Further to a meeting of its Planning Committee Advisory Group held on 14th December 2021 and pursuant to a scheme of delegation dated 4th May 2021, the Clerk submits the attached comments on behalf of the Parish Council in respect of the following applications:

P/155/21/RES – Land West of Pagham Road Pagham. Approval of reserved matters (layout, scale, appearance and landscaping) following outline consent P/140/16/OUT for the “local centre” parcel which comprises of retail, community, and commercial uses, 20 No residential apartments and a 70 bed care home.

6.4 P/158/21/RES – Land West of Pagham Road Pagham. Approval of reserved matters (layout, scale, appearance and landscaping) following outline consent P/140/16/OUT for the “local centre” parcel which comprises of retail, community, and commercial uses, 20 No residential apartments and a 70 bed care home (alternative scheme to P/155/21/RES).

The Parish Council wishes to OBJECT to these applications for the following reasons:

TITLE:
SPINE ROAD AND
LOCAL CENTRE ACCESS

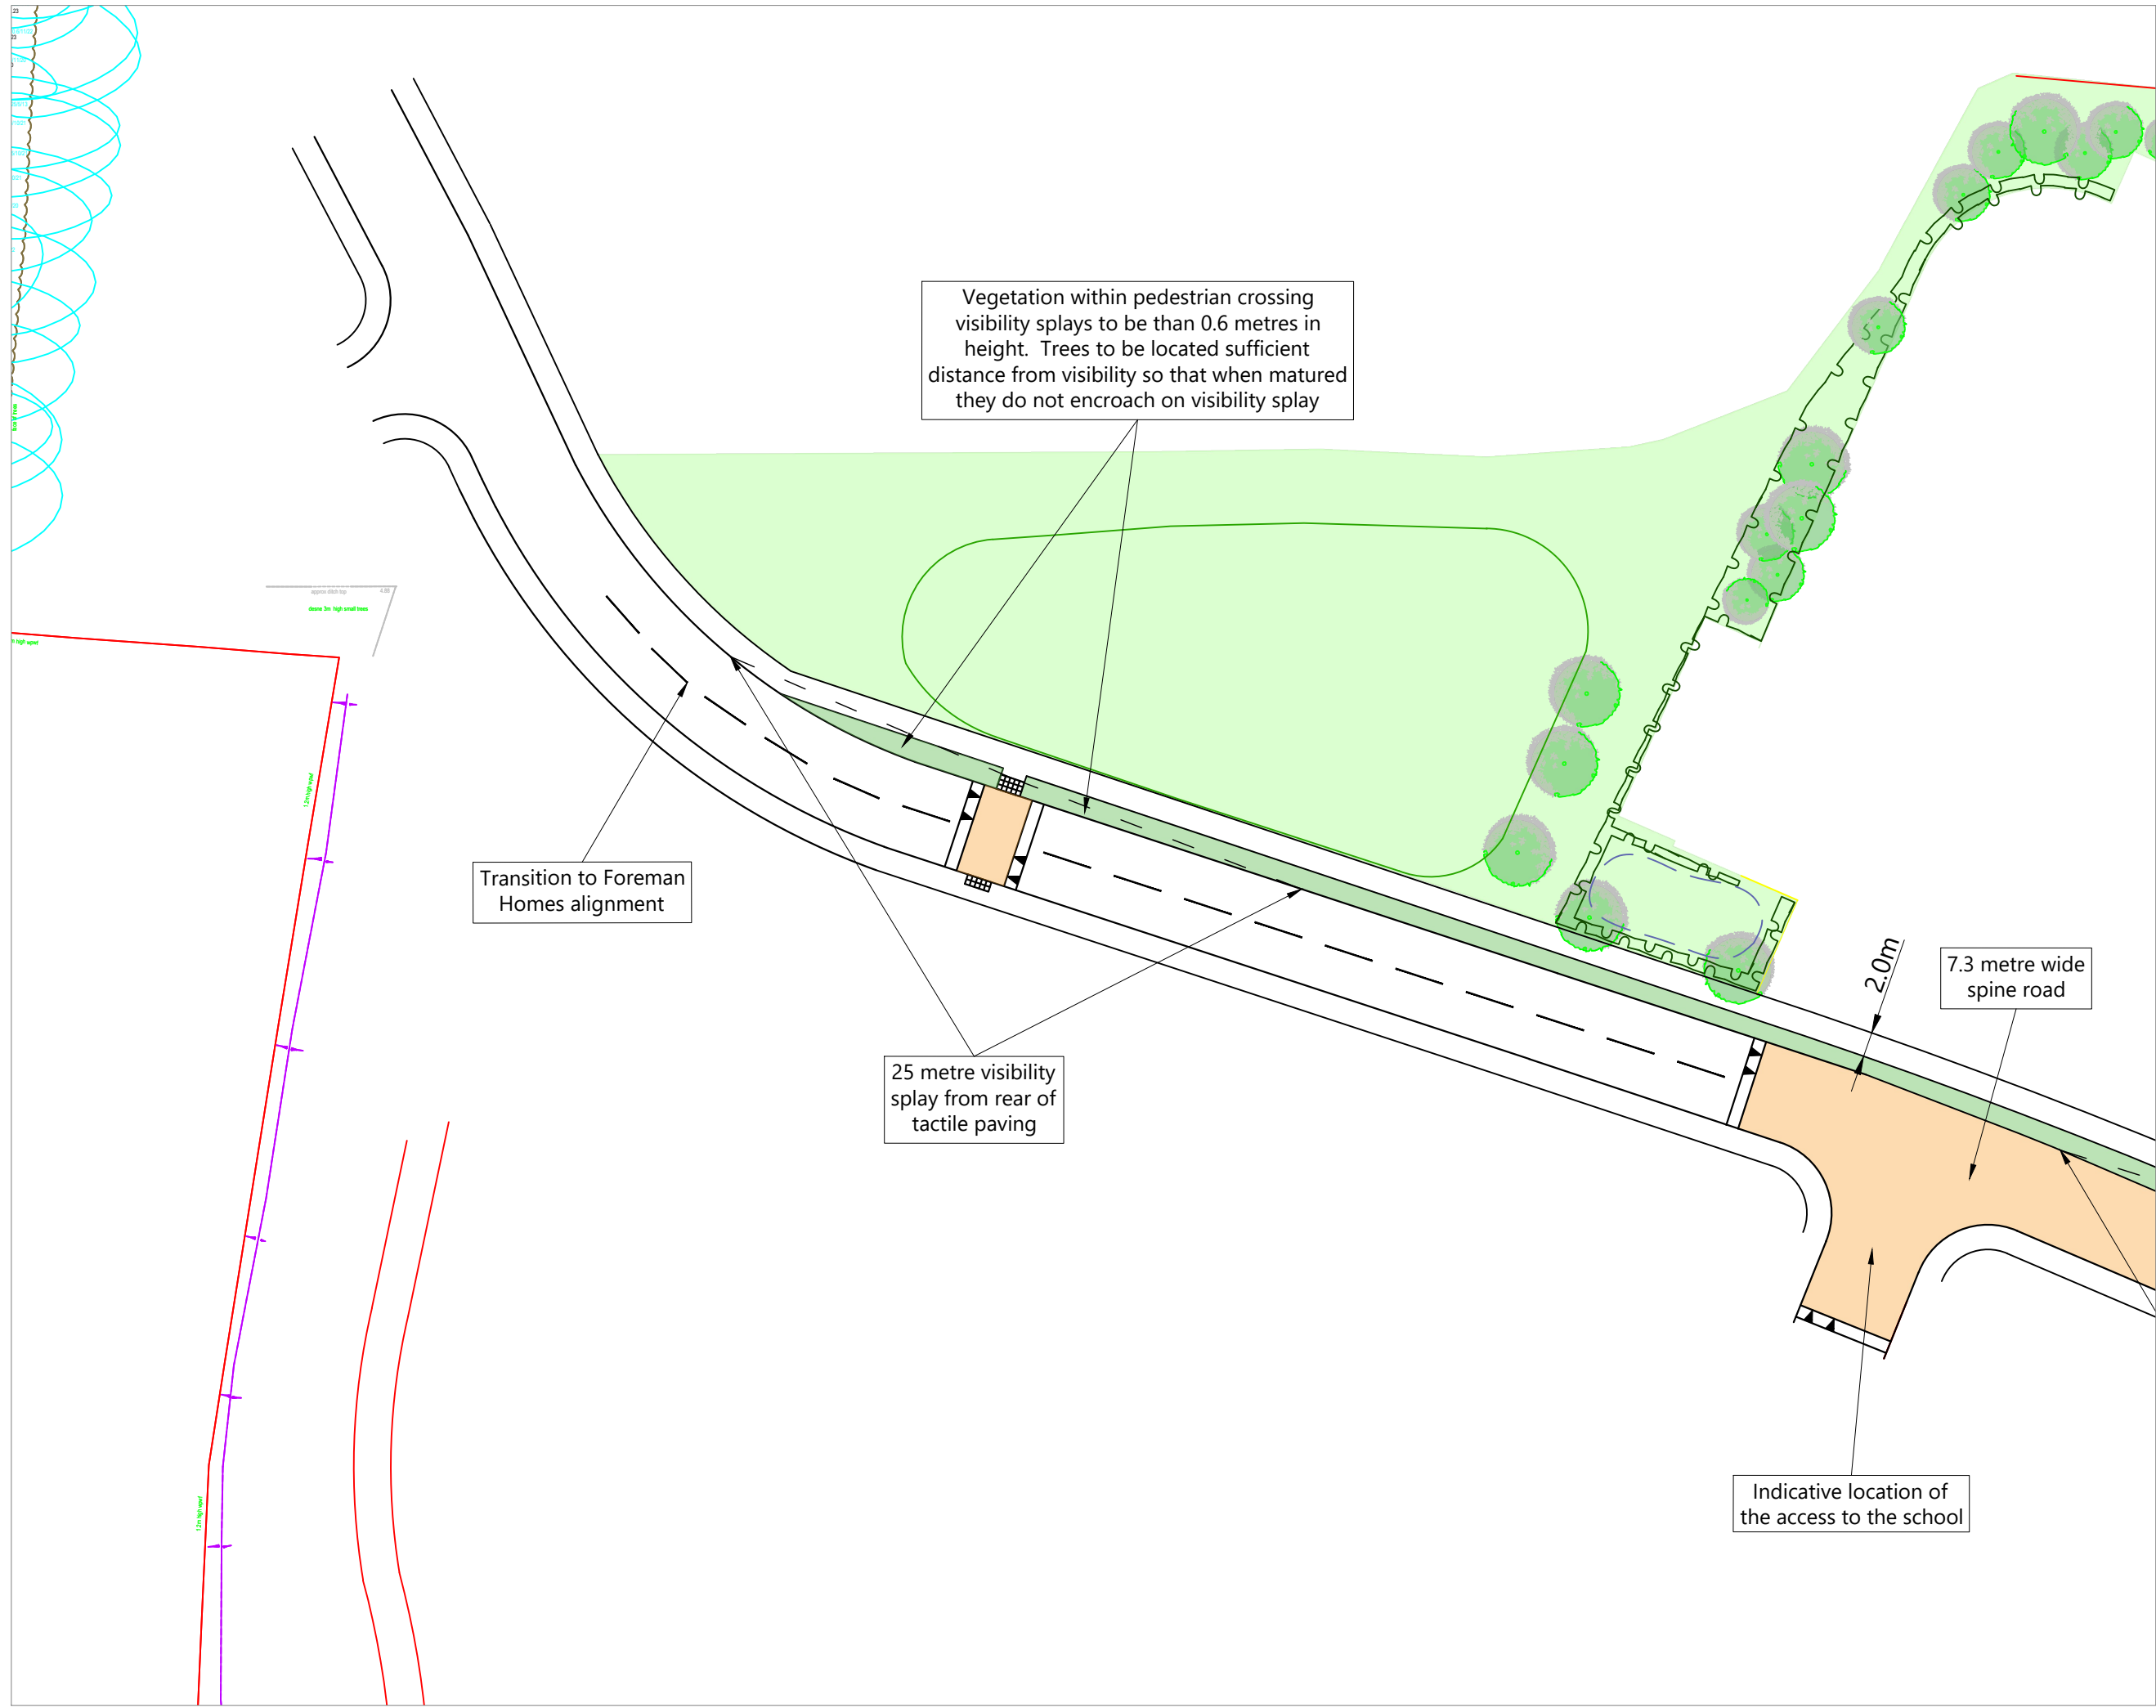
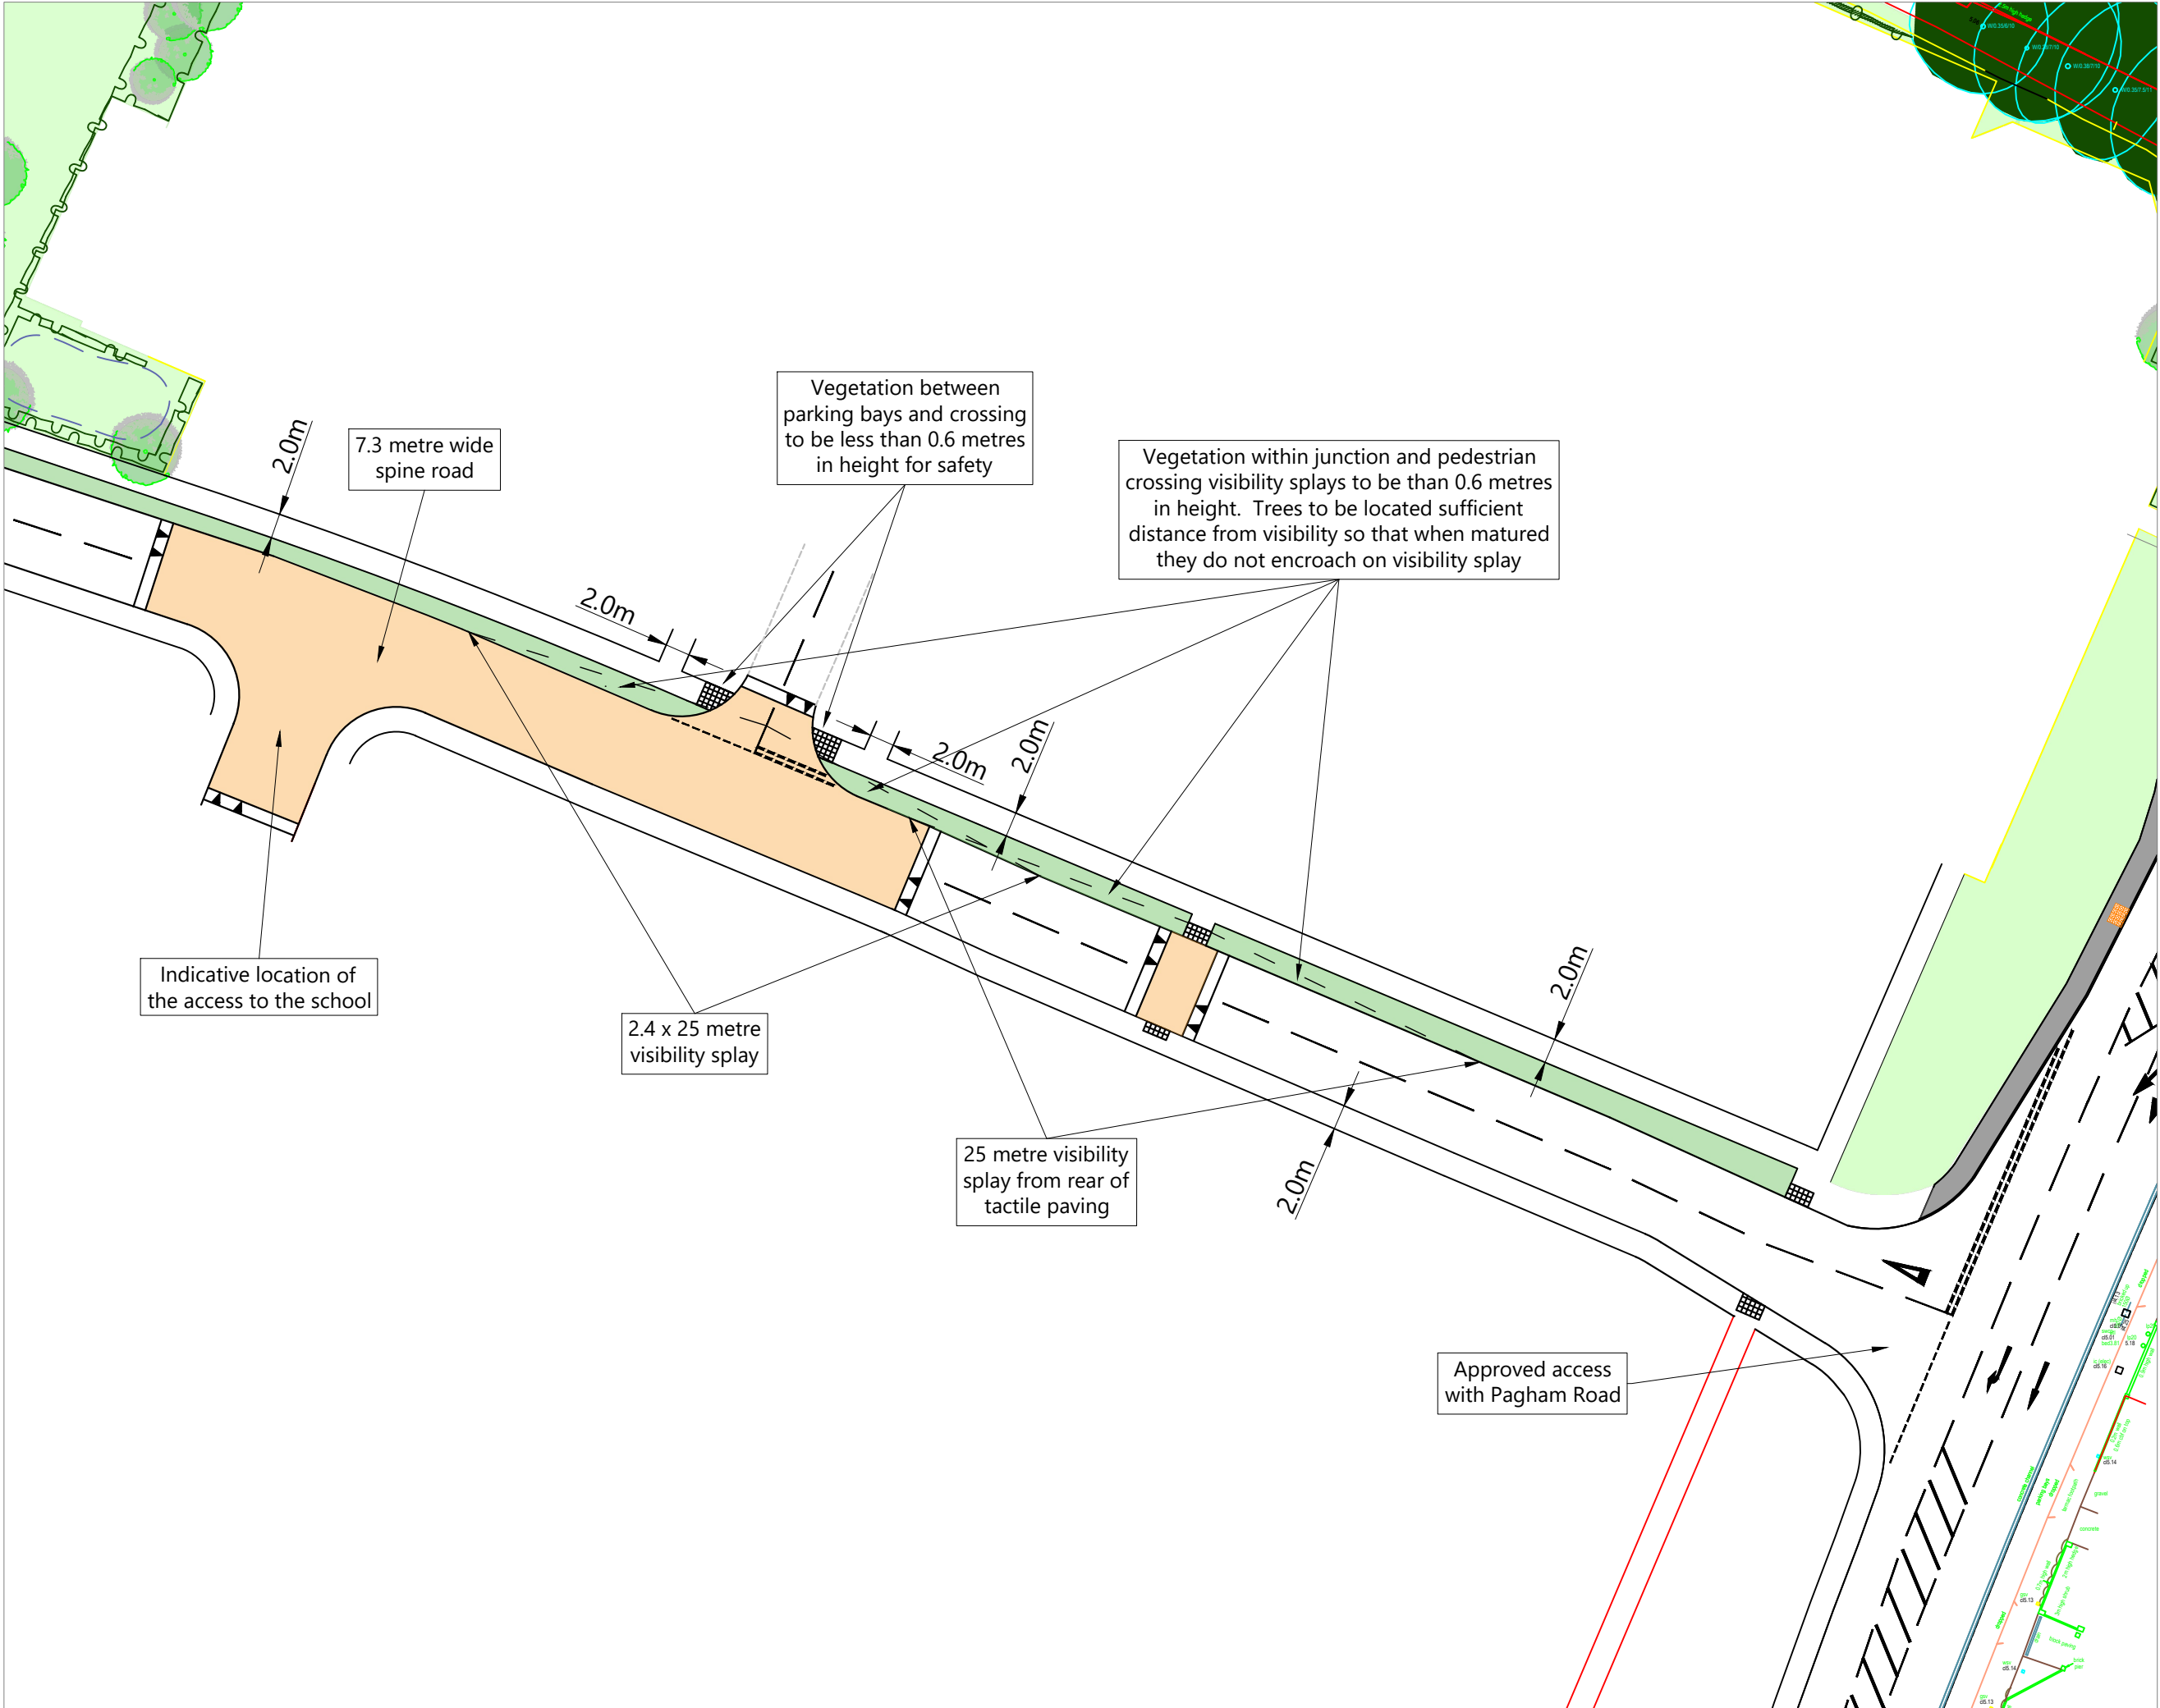
The Council would like to support the comments of the Local Highways Authority in respect of the need for far more detail and consideration to be given to the proposed school site. Whilst it is accepted that it is not within the gift of the applicant to deliver the school, all the strategic sites in Pagham are reliant upon its delivery and it must be assumed to be going ahead. It is vital that adequate account is taken of the traffic generated by the school – it

does not just serve this site, and parents will inevitably drive to the school from the Pagham North developments. We support the calls for a road safety audit, but believe a wider spine road is preferable as parents will, despite measures to encourage otherwise, park on the road to drop off and pick up children.
